CITY OF ALBUQUERQUE

**Re: Taos II at the Trails Subdivision
Erosion and Sediment Control Plan
Engineer's Stamp Date 10-18-16 (C09E001G)**

**Erosion Sediment Control Plan**

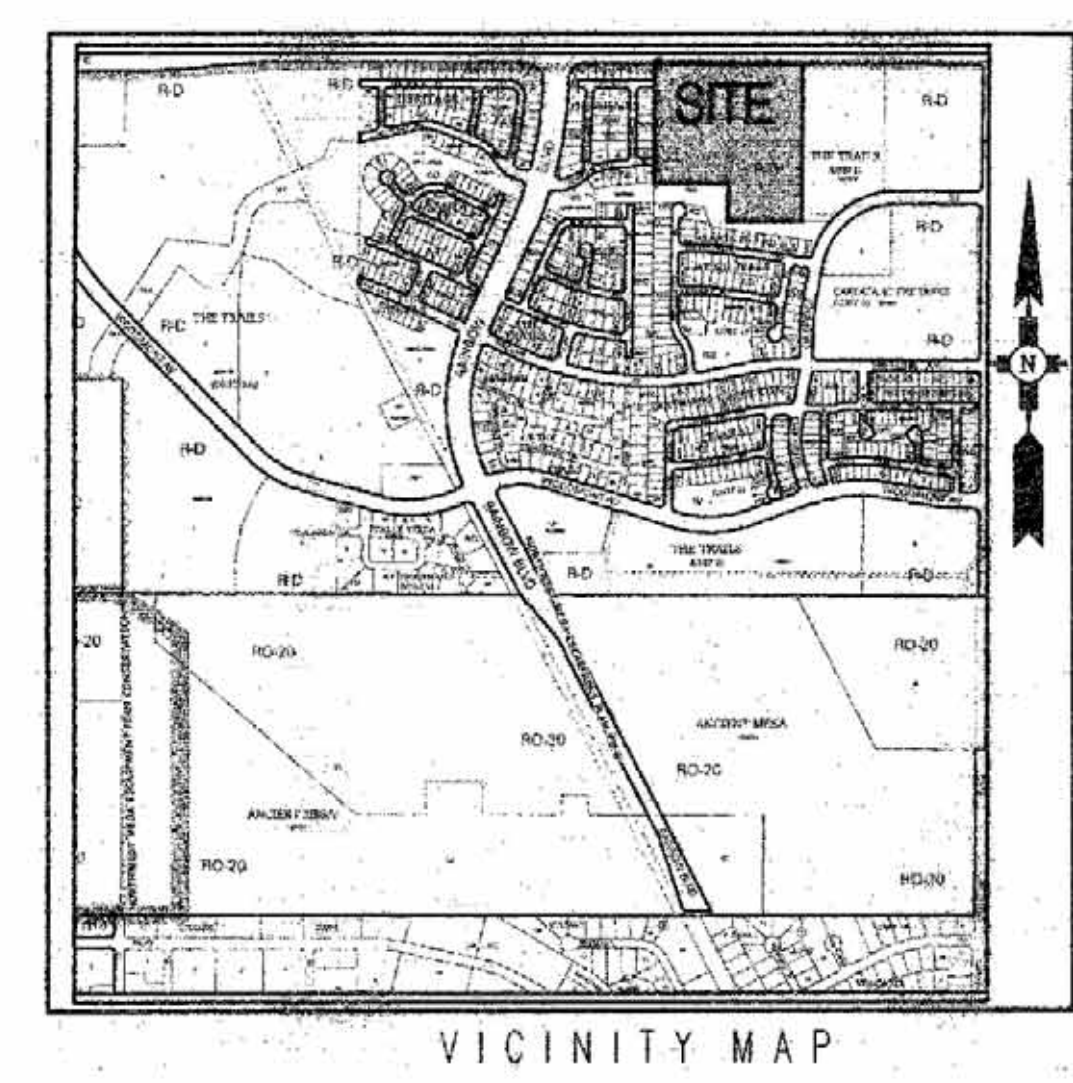
The plan cannot be approved for Work Order since it does not show any BMPs for the widening of Paseo del Norte as shown on the approved Infrastructure List.

In addition, a haul road has been used in the Paseo del Norte ROW to deliver dirt to the site. It appears there is a low point near the east end of it which may act as a sediment basin. If drainage from the haul road makes it past (east) of this low-point, a sediment BMP shall be installed to prevent sediment from reaching Universe Blvd. See image attached to the e-mail for location of the haul road.
